From: Amanda Scholes on behalf of Planning.Responses
Sent: 04 November 2020 13:13
To: Planning Scanning
Subject: FW: AL/64/20 Springfield Hook Lane Aldinbourne - Highways Re-consultation for tracking diagrams

Subject: AL/64/20 Springfield Hook Lane Aldinbourne - Highways Re-consultation for tracking diagrams

Subject: AL/64/20 - Springfield Hook Lane Aldingbourne

SWEPT PATH ANALYSIS
LARGE REFUSE ENTERING/EXITING SITE

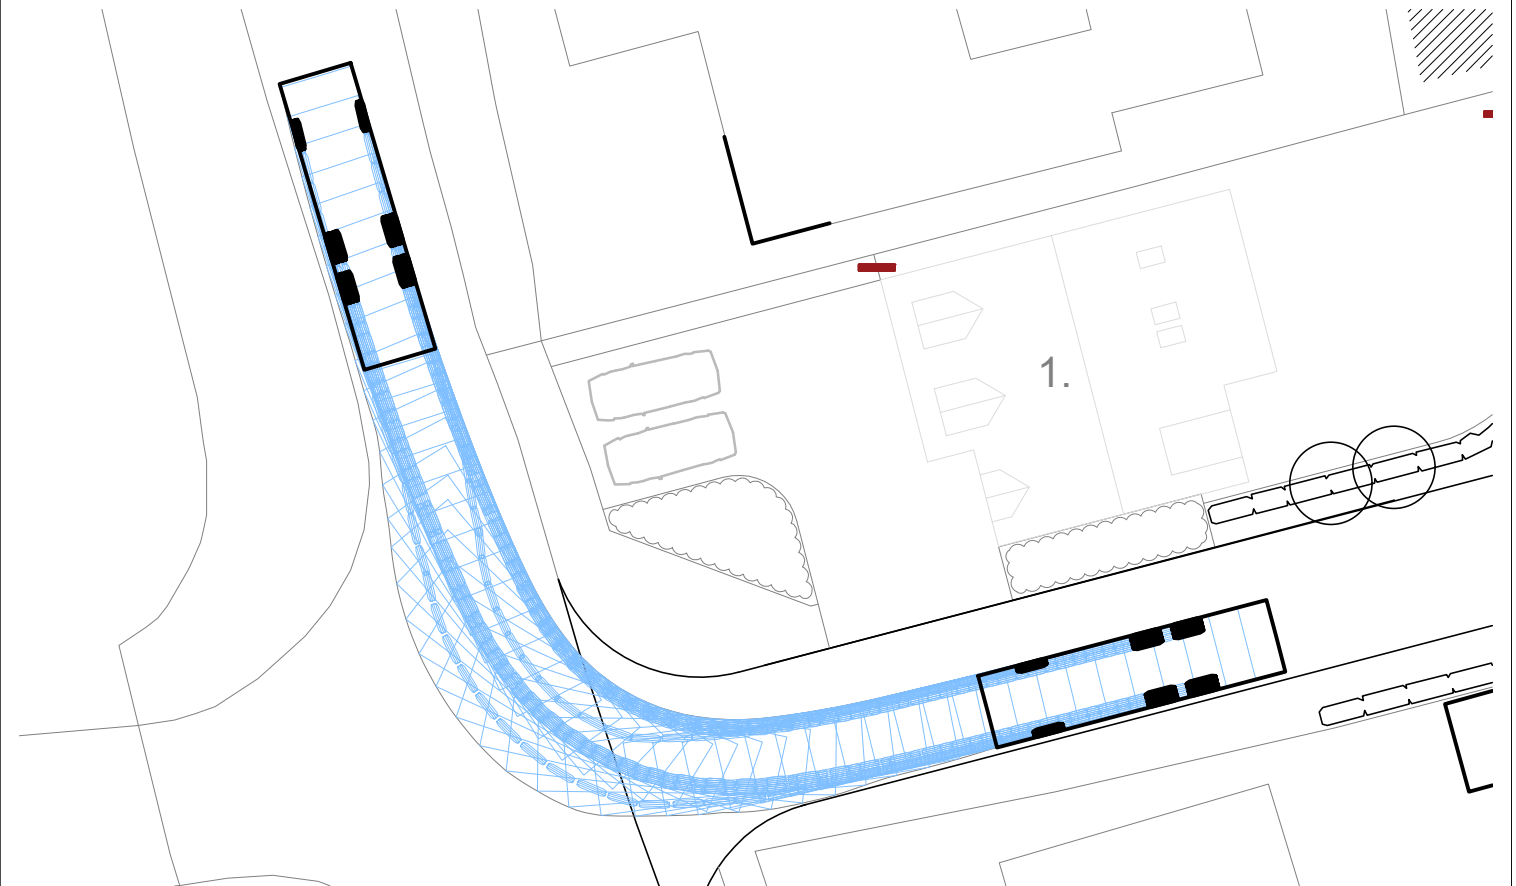
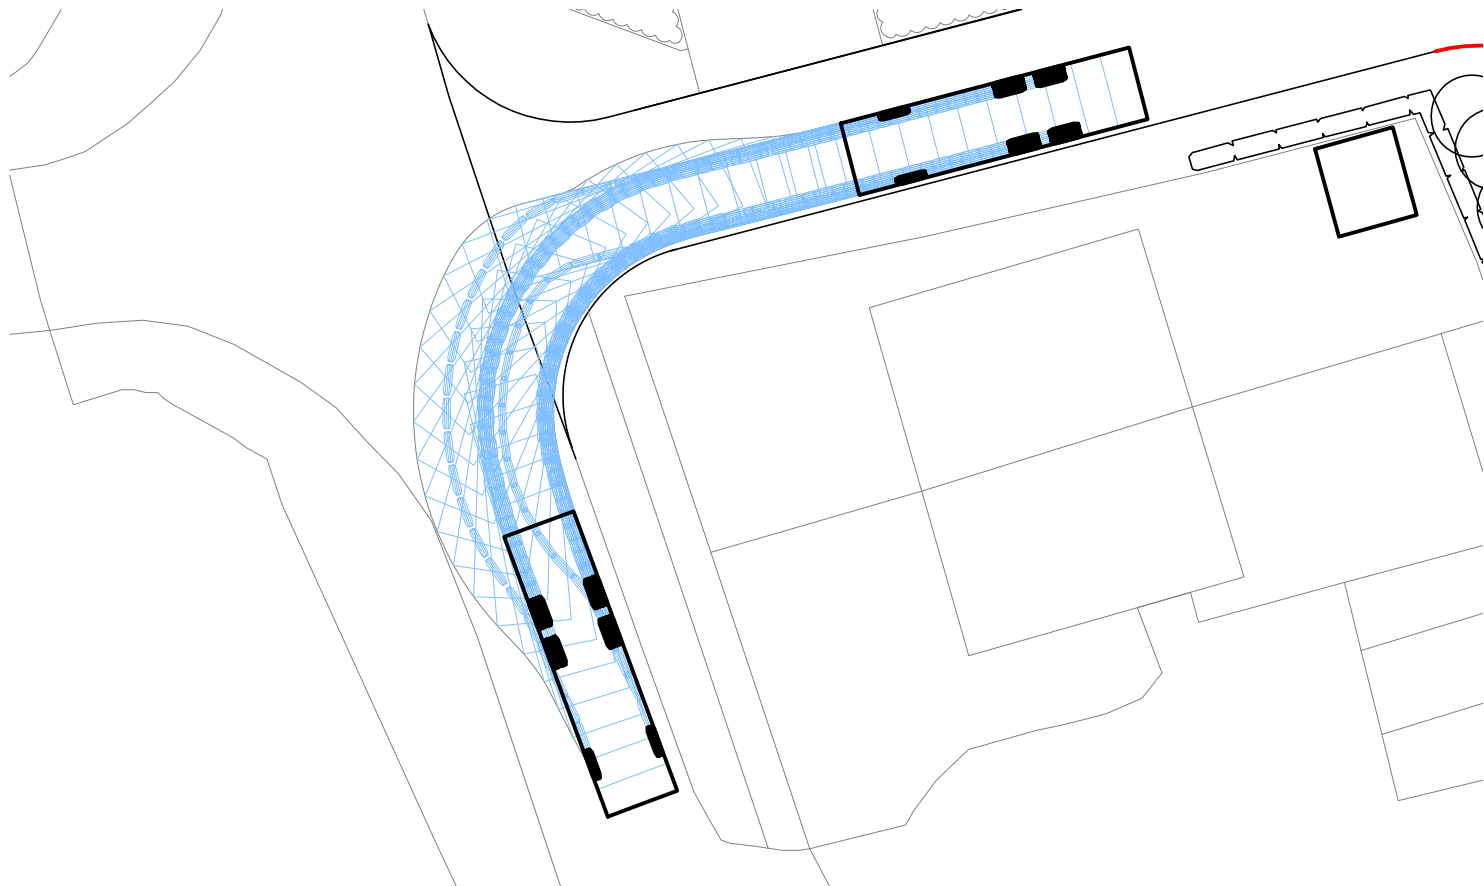
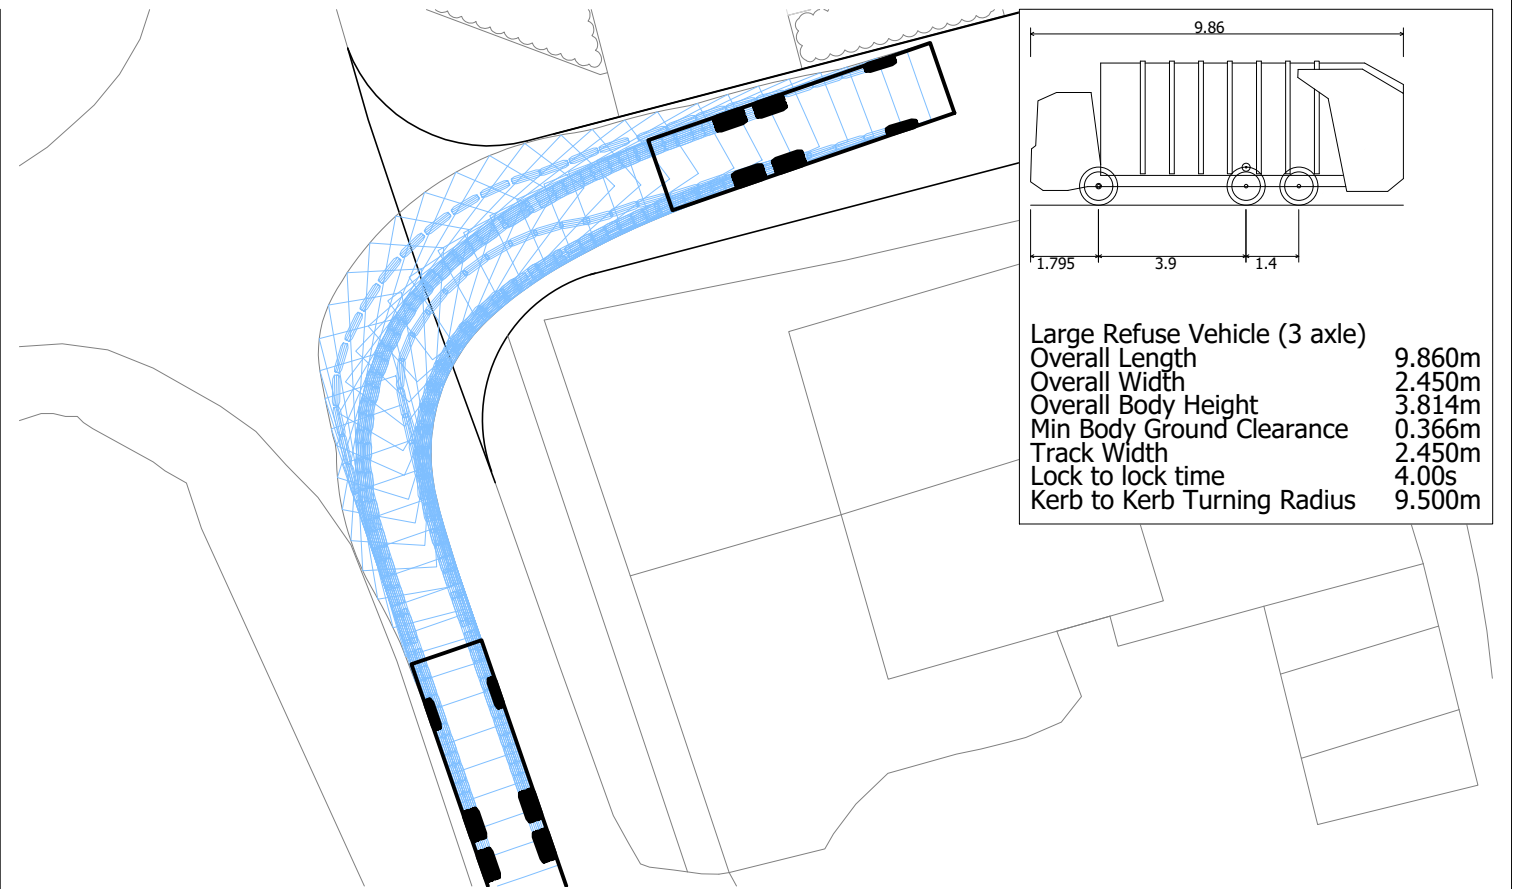
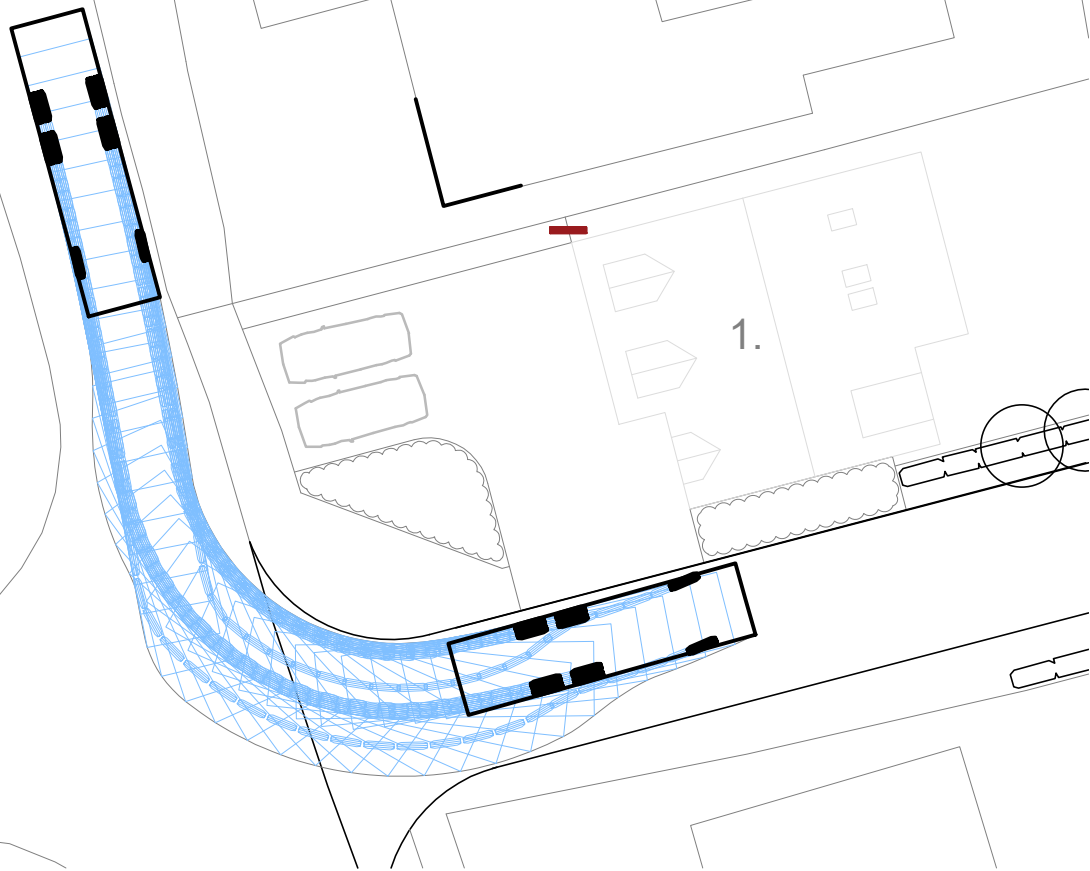
We have reviewed the supplied tracking drawings and would raise no concerns to these. It would be an idea to make sure all parking and turning areas are used for their intended use so a Parking & Turning Condition would be advised.

Condition - Vehicle parking and turning

No part of the development shall be first occupied until the vehicle parking and turning spaces have been constructed in accordance with the approved plan. These spaces shall thereafter be retained for their designated use.

SWEPT PATH ANALYSIS
LARGE REFUSE TURNING ON SITE

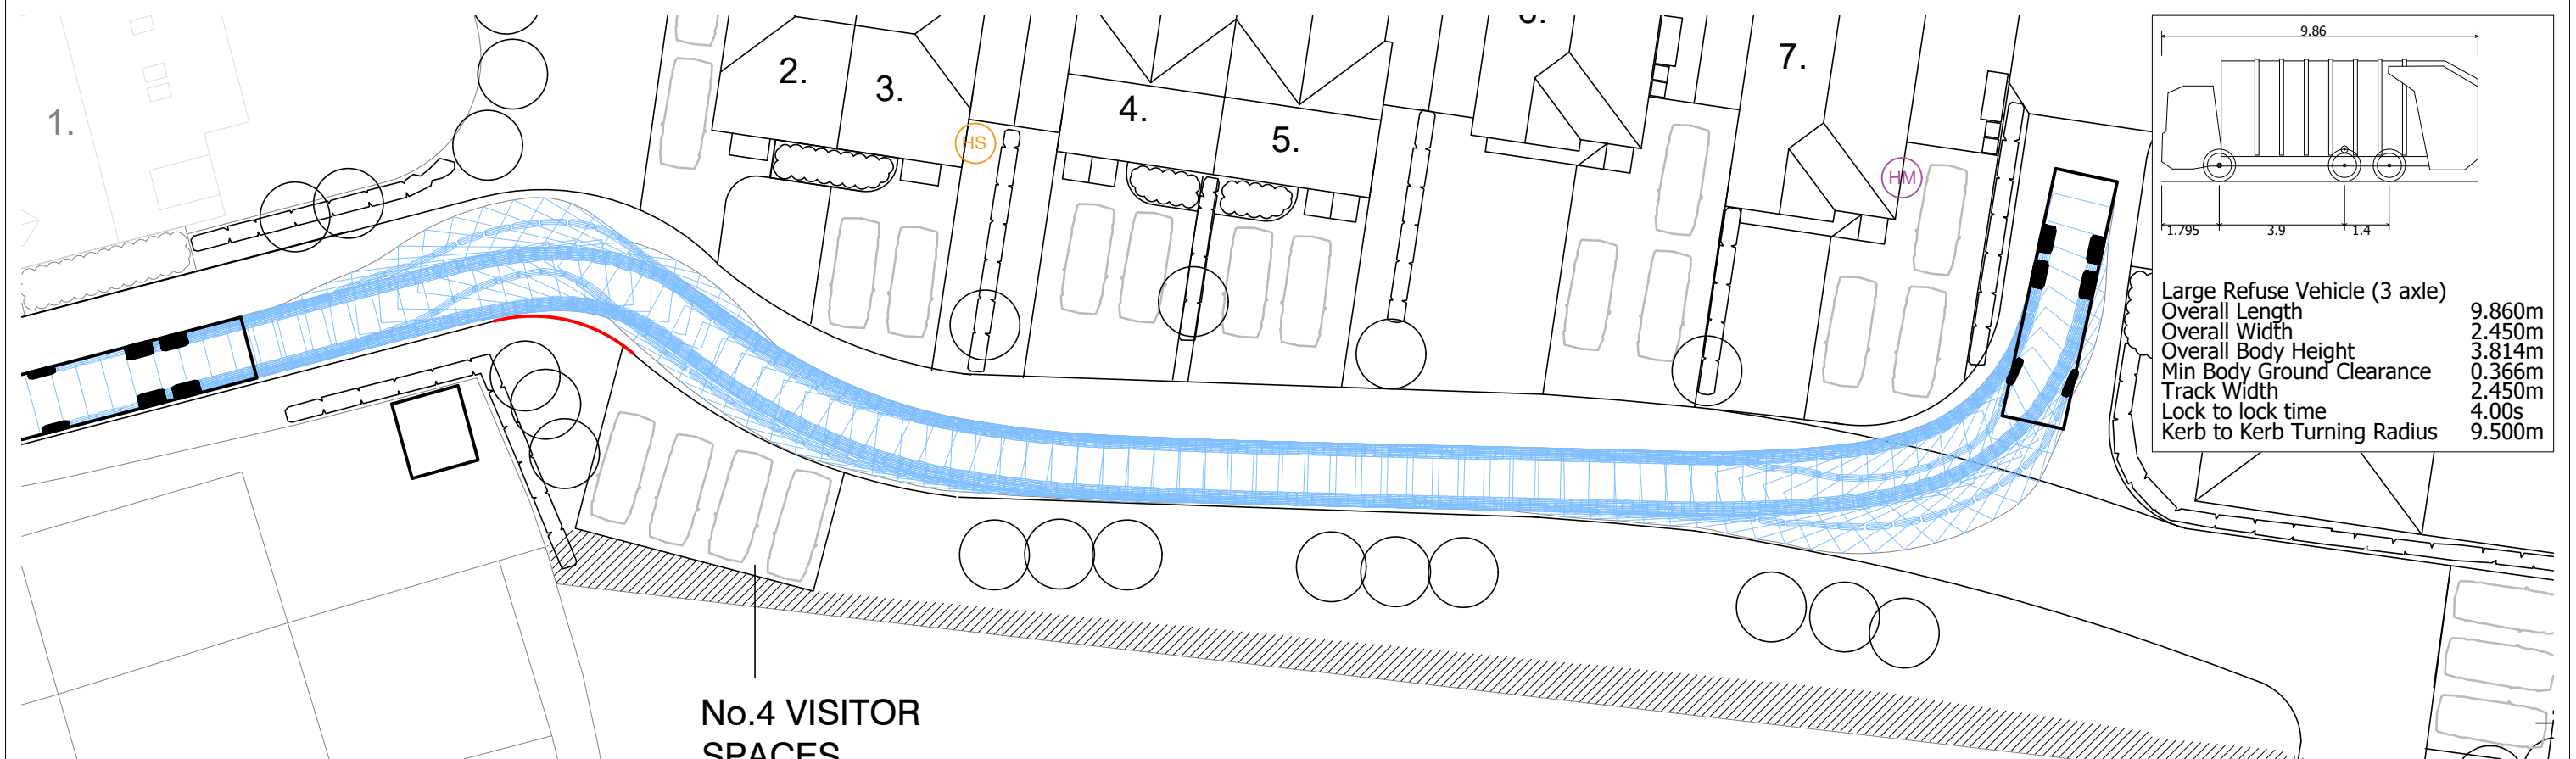
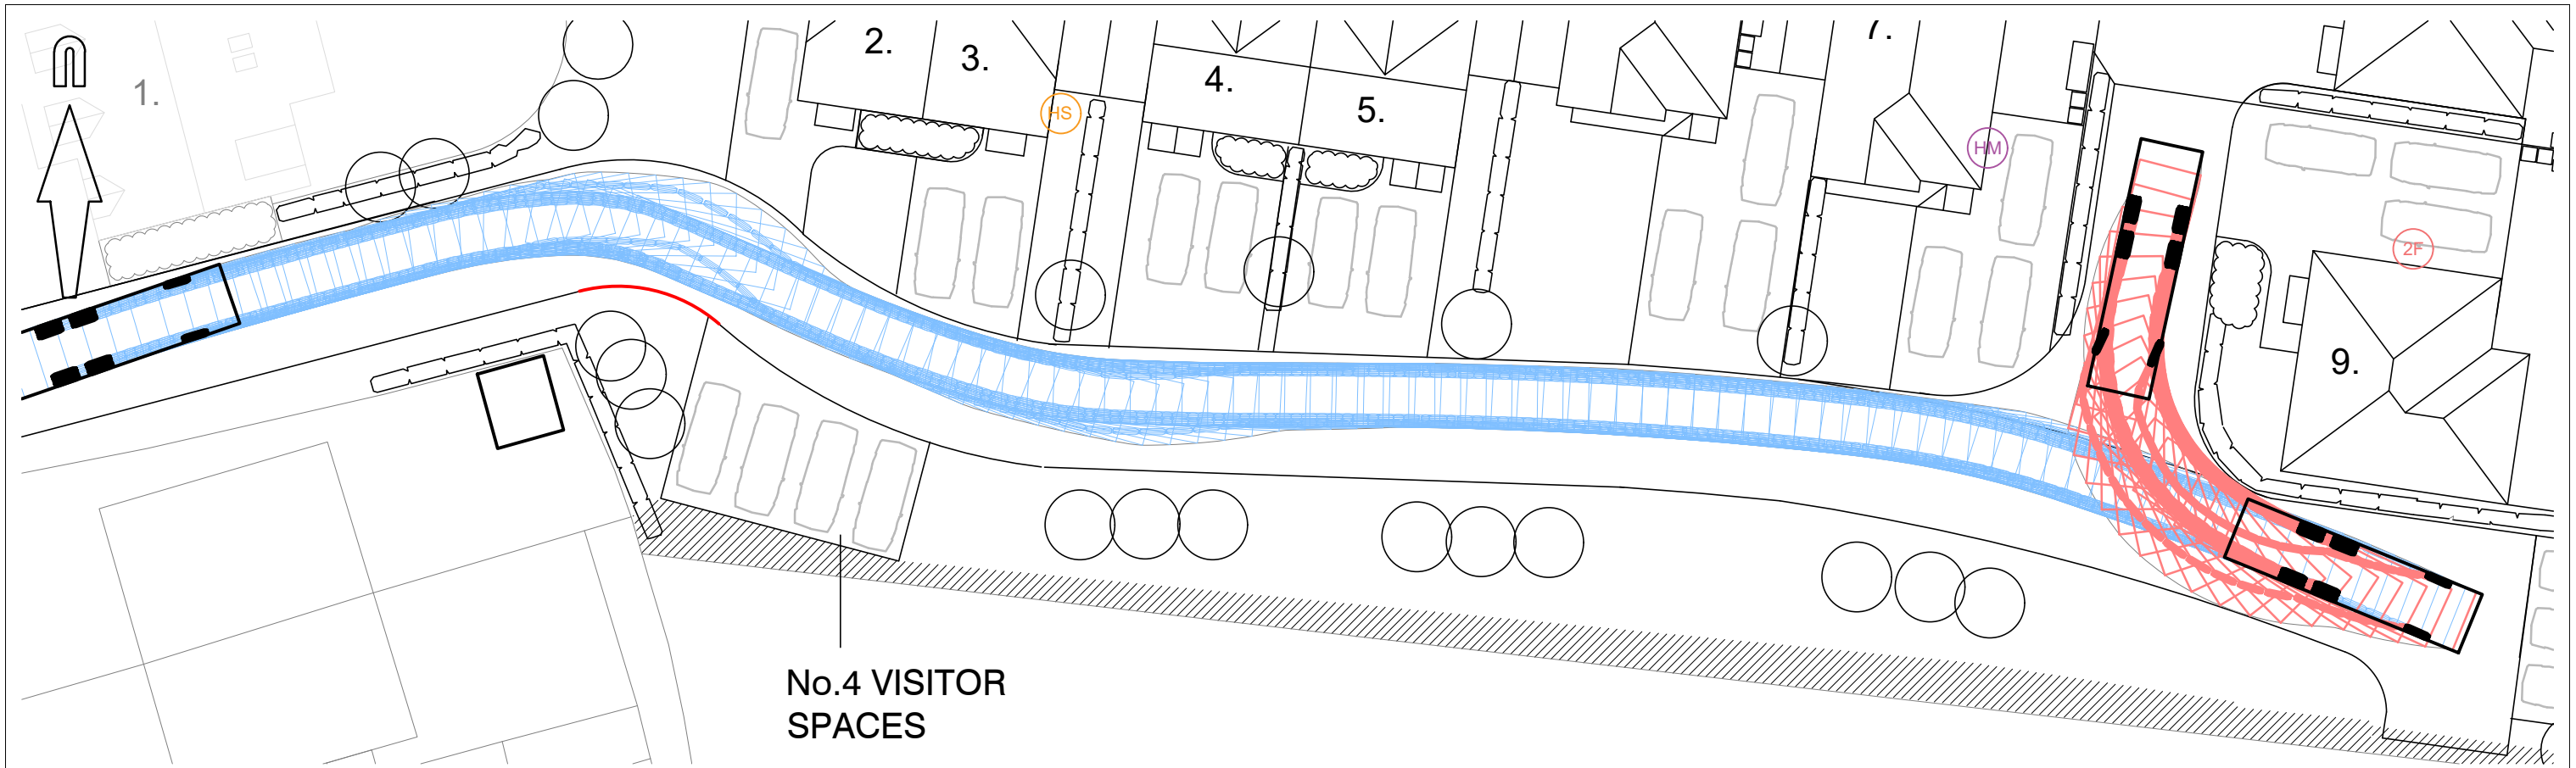
I've just been reviewing the revised site layout, drawing no: 1186/DP04 Rev 01. In general the LHA would raise no concerns and the previously proposed conditions should still stand (under AL/27/20). I have noticed though that the dedicated turning head has been lost somewhat in the design and now also accommodates visitor parking spaces. The applicant needs to provide some tracking of a refuse vehicle to demonstrate that a collection vehicle can turn fully on site and enter the highway in forward gear. Also that any parking arrangements will not hinder this movement.
